WEST SUSSEX COUNTY COUNCIL CONSULTATION

TO:	Arun District Council FAO: Hebe Smith
FROM:	WSCC – Highway Authority
DATE:	24 September 2026
LOCATION:	Land West Of Ryefield Farmhouse Oak Tree Lane Woodgate PO20 3GU
SUBJECT:	AL/63/26/DOC Approval of details reserved by condition under AL/31/22/PL relating to Condition 4 - External Materials & Finishes; Condition 8 - Hard & Soft Landscaping; Condition 9 - Construction and Biodiversity Management Plan and Condition 10 - Broadband Provision. PLANTING PLANS AND CEMP received.
DATE OF SITE VISIT:	n/a (desktop study undertaken for purposes of this DOC application)
RECOMMENDATION:	More Information required

This is the **second** WSCC Highways response to the above planning application seeking approval of details reserved by condition under AL/31/22/PL relating to Condition 4 - External Materials & Finishes; Condition 8 - Hard & Soft Landscaping; Condition 9 - Construction and Biodiversity Management Plan and Condition 10 - Broadband Provision.

VEHICLE DETAILS: (N.T.S.)

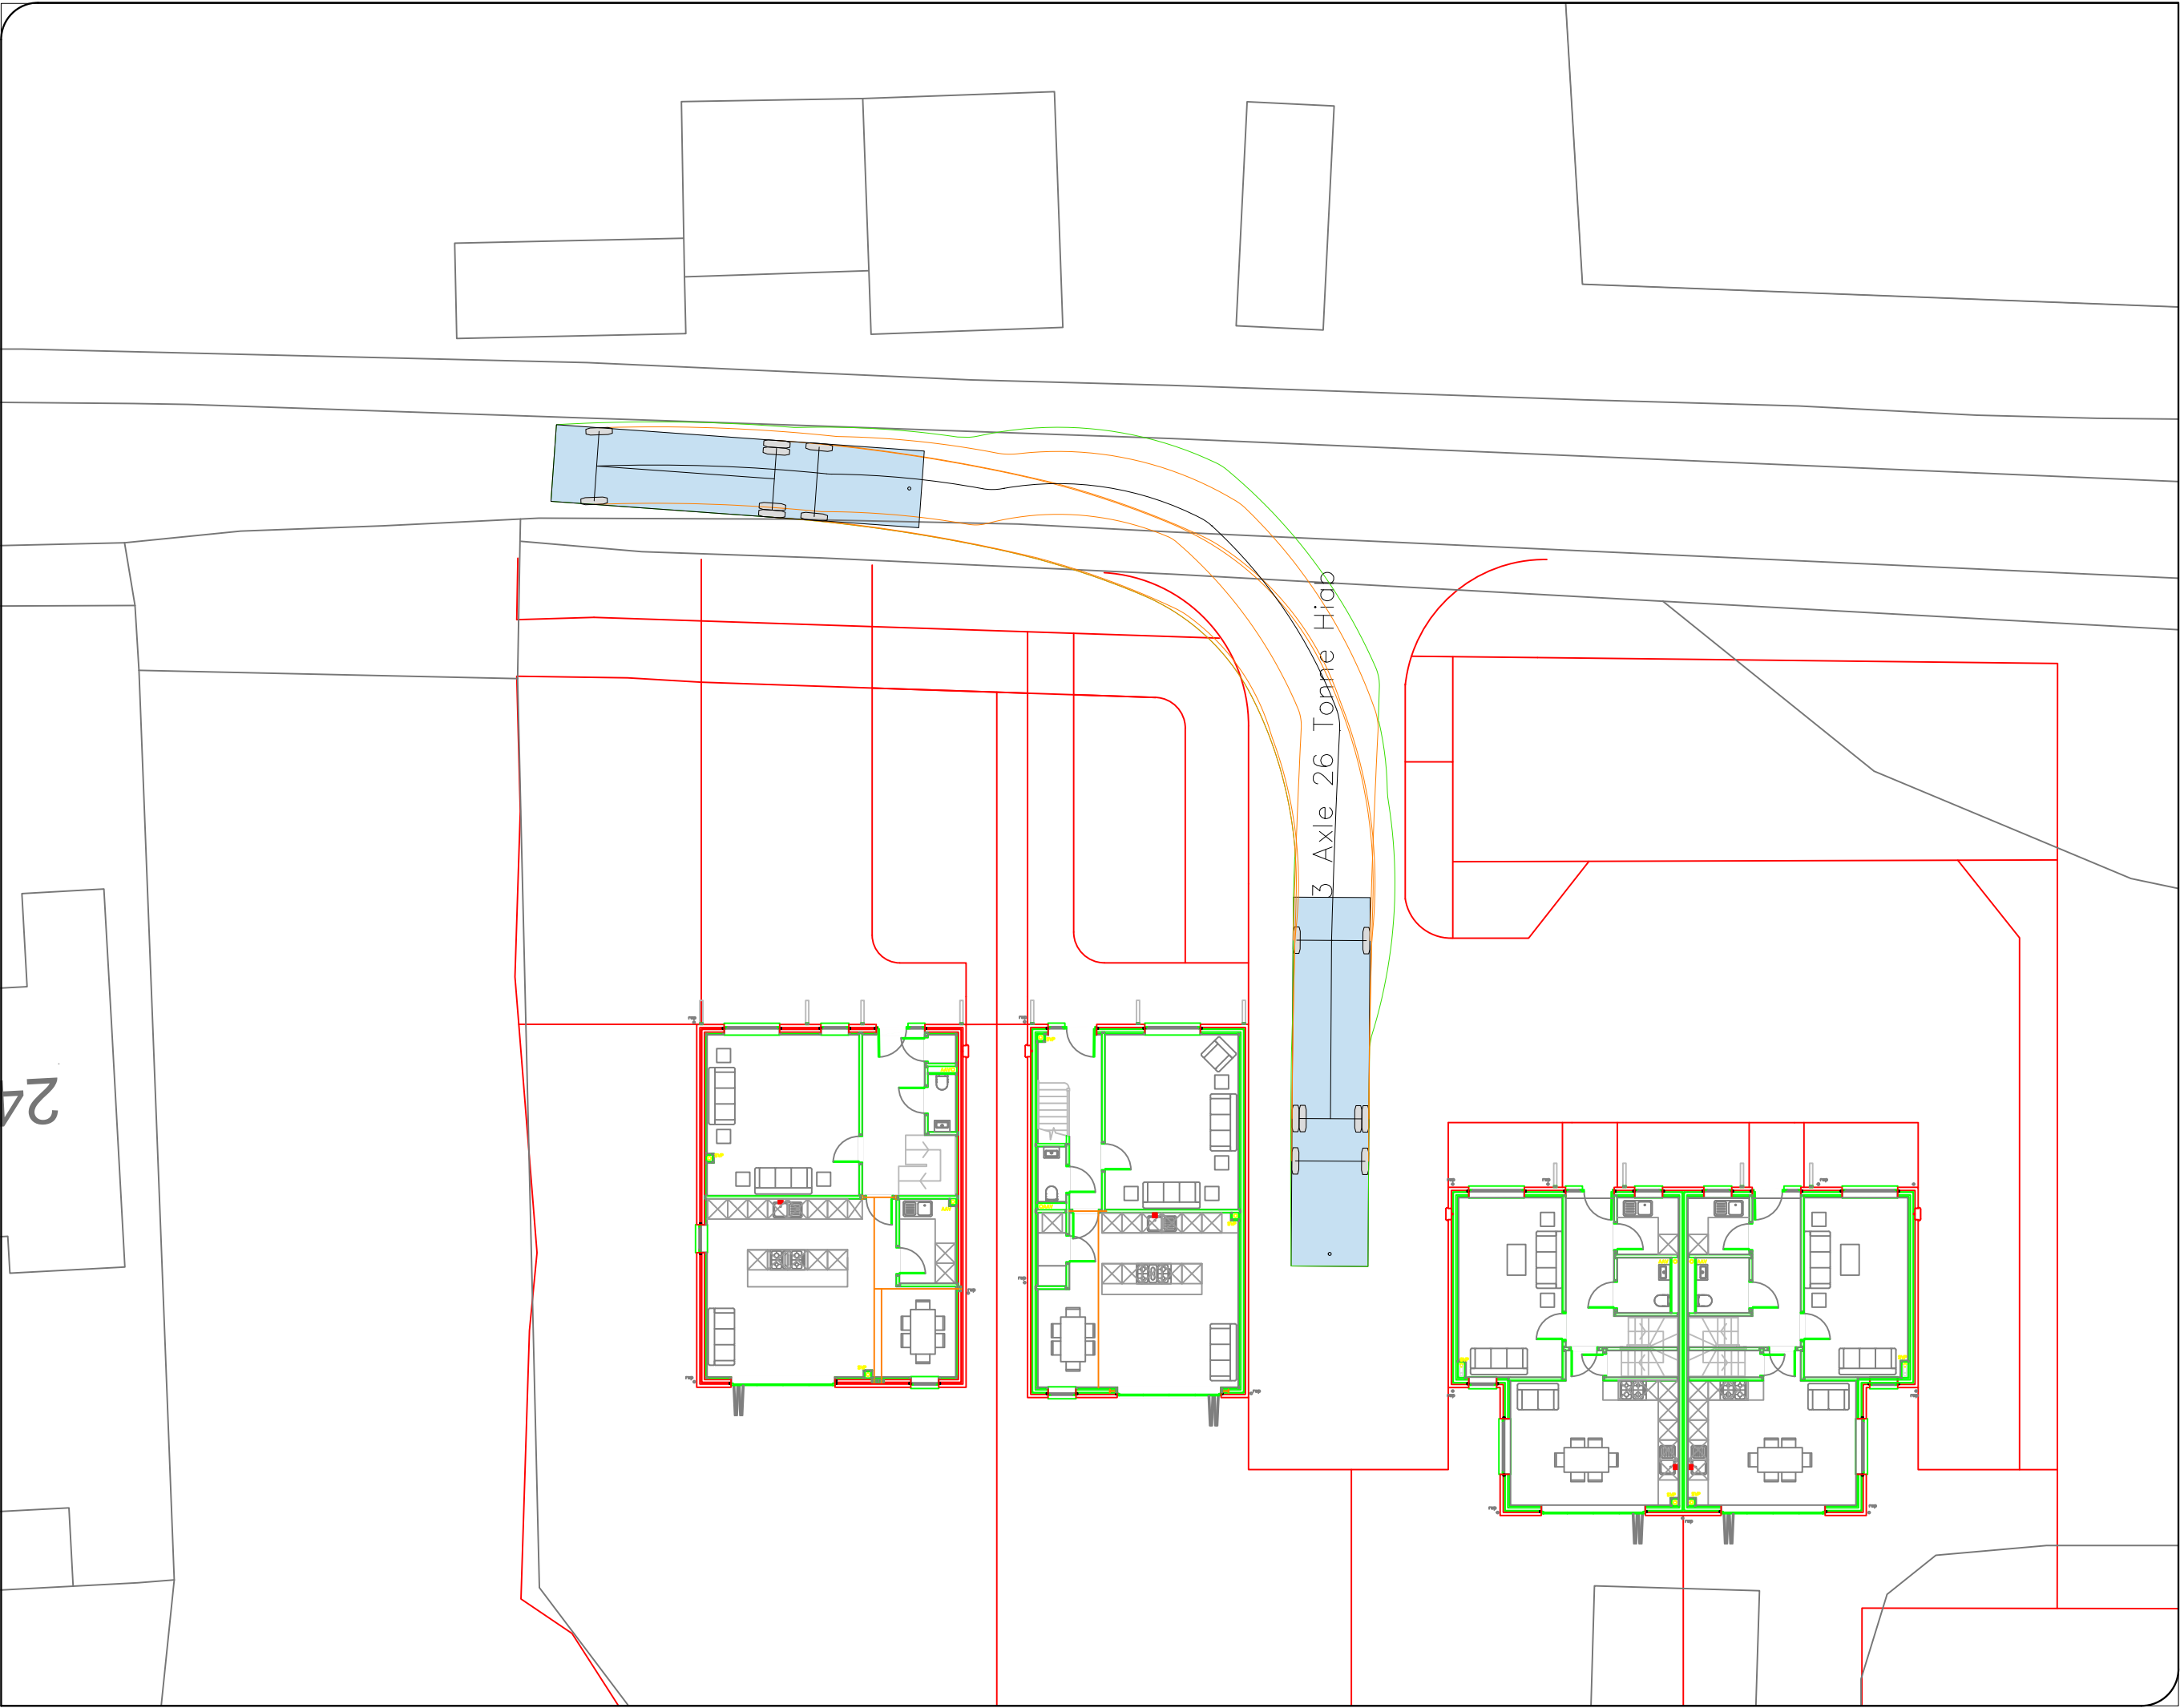
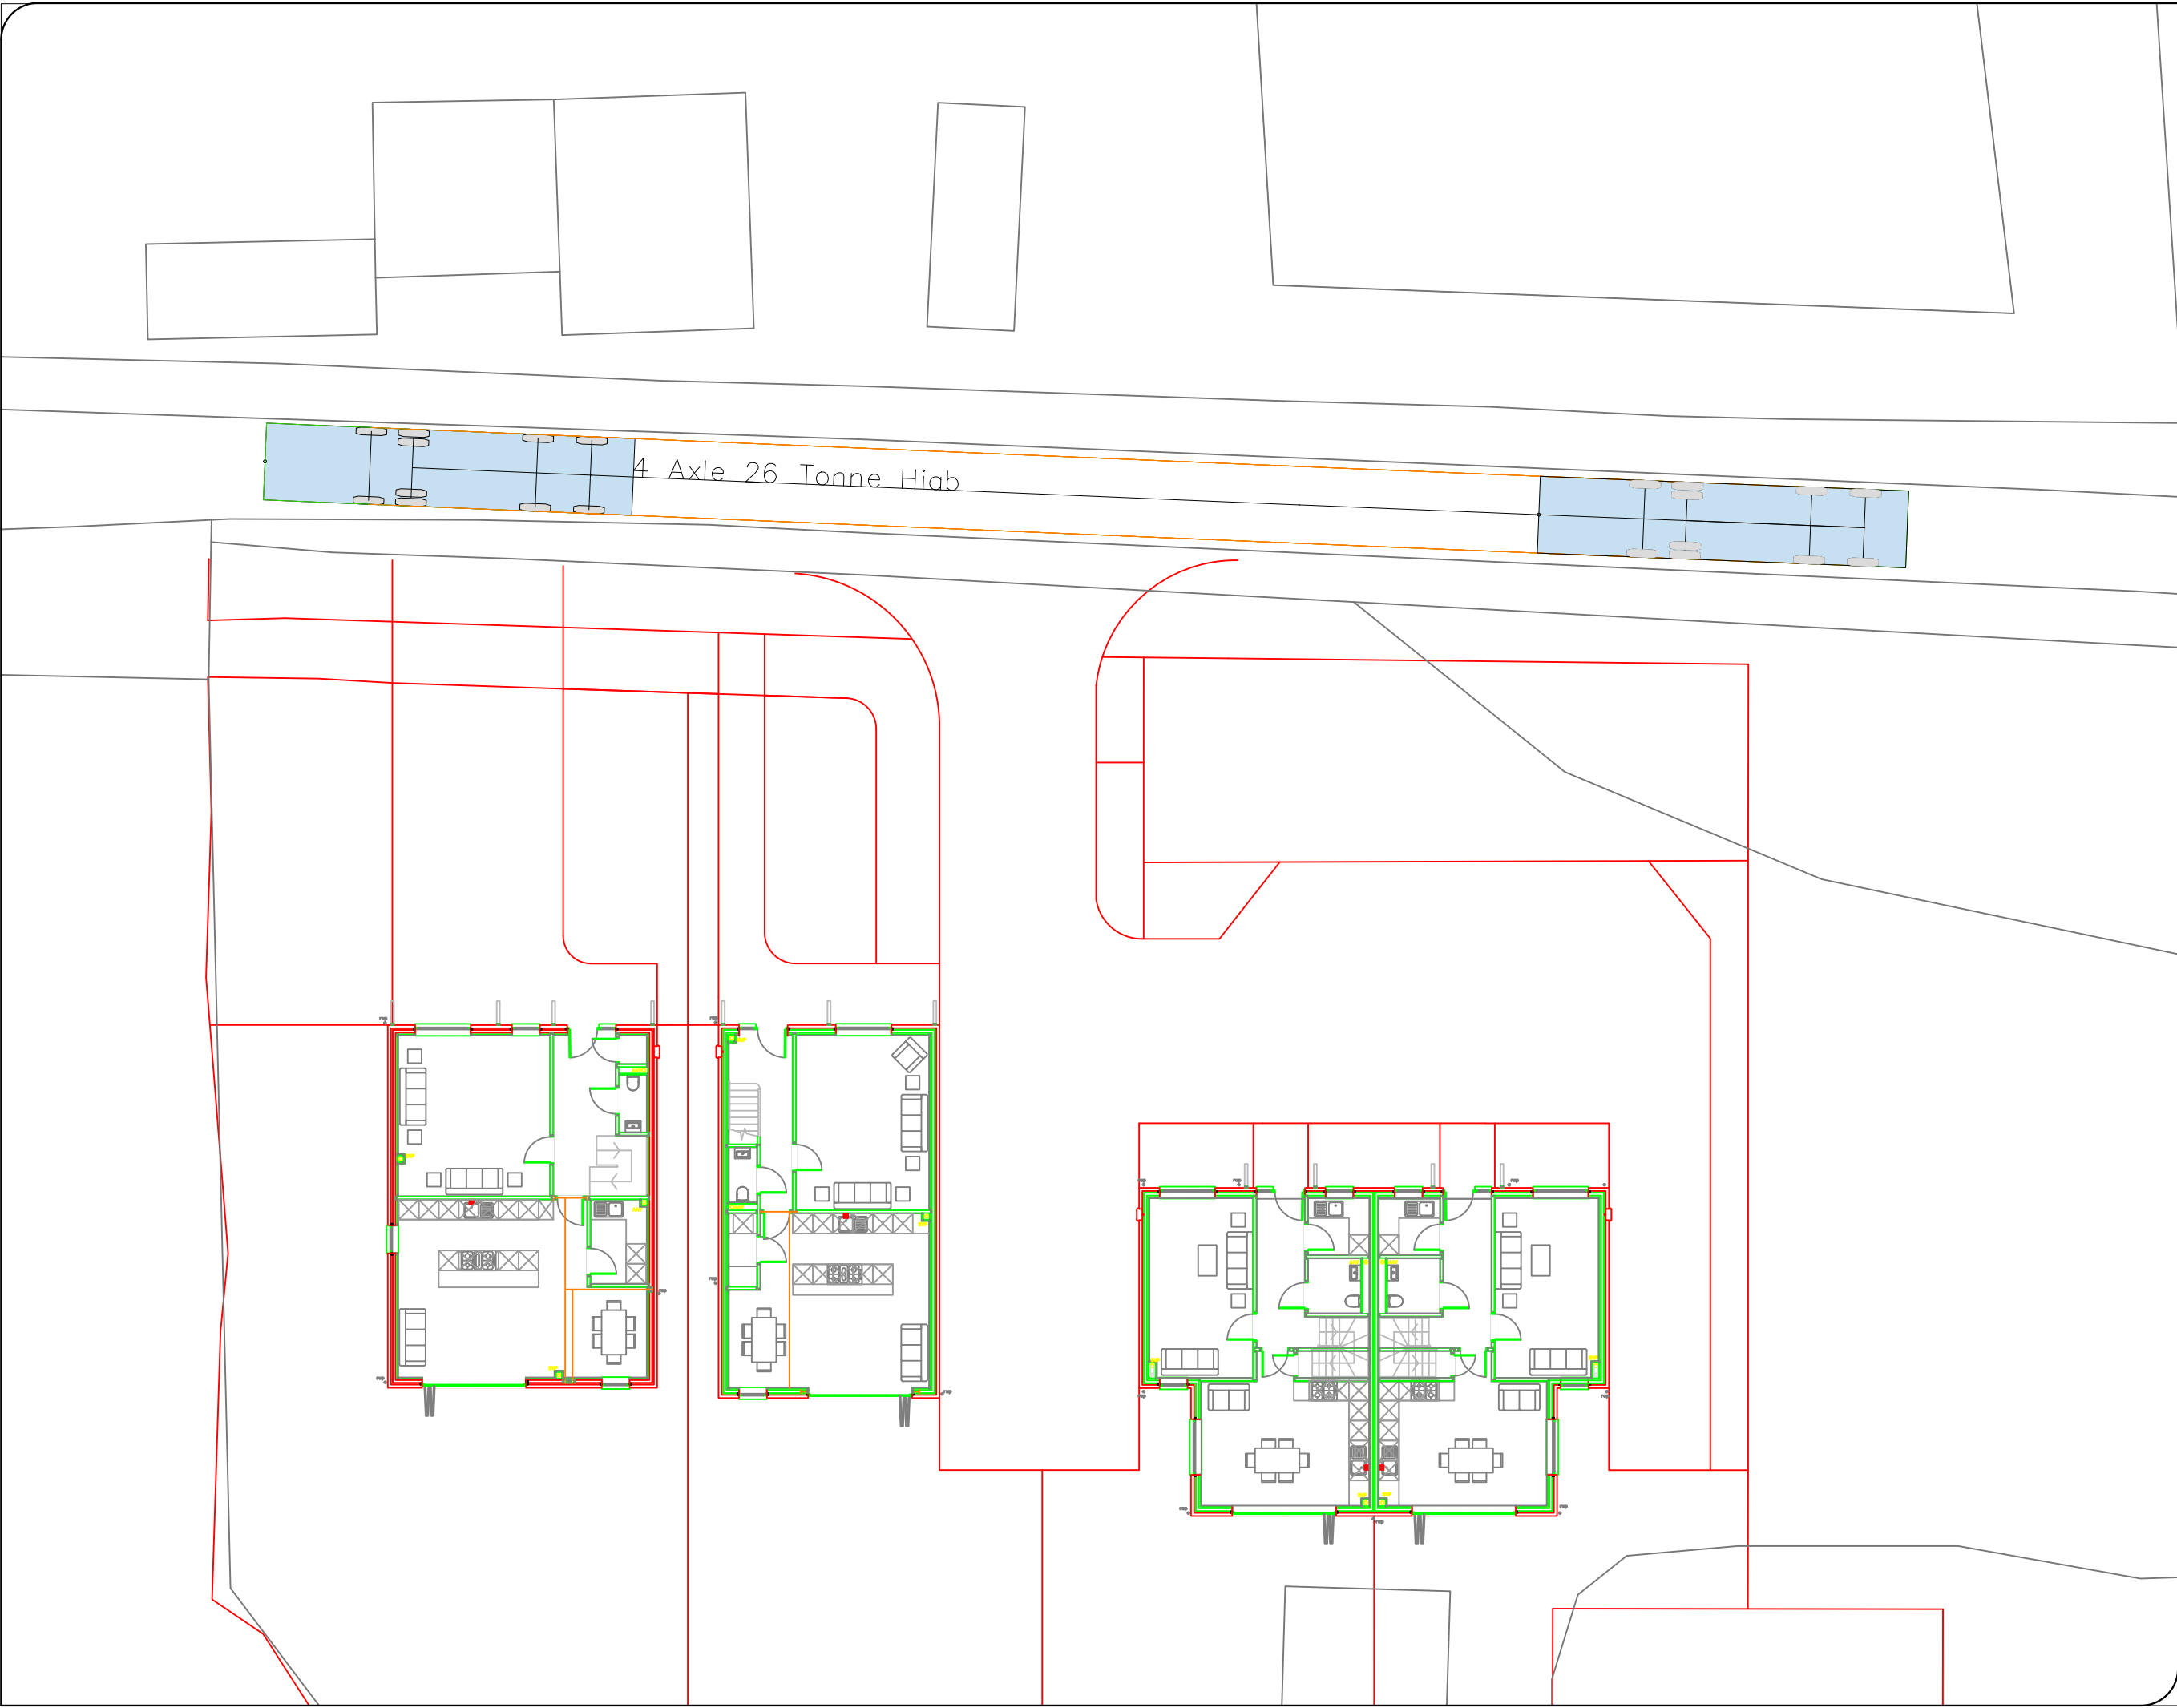
2. Condition 9 – Construction and Biodiversity Management Plan. Out of hours contact details should be included in any approved CEMP and additionally, made available to local residents and displayed on the site hoarding. *Now included on page 8 of the revised/updated CBMP.* With regard to turning of vehicles clear of the access 'road', the CEMP does not show how construction-related vehicles would be able to do this. Any final CEMP should show how all sizes of vehicles will be able to enter and exit the site (and turn within it) without having to reverse along Oak Tree Lane. *A plan is shown on page 5 of the revised/updated CBMP. However, this simply shows that a car/small van-sized vehicle could enter and leave the site in a forward gear and turn within it. No further analysis is provided for other vehicles expected to access the site during the construction phase. Paragraph 4.3.1 found on page 11 of the revised/updated CBMP makes reference to turning being available within the site for vehicles. However, the swept path analysis, recommended by the Highway Authority previously, is not shown for any vehicles larger than a car or small van. As such, the document should be further updated to include this.*
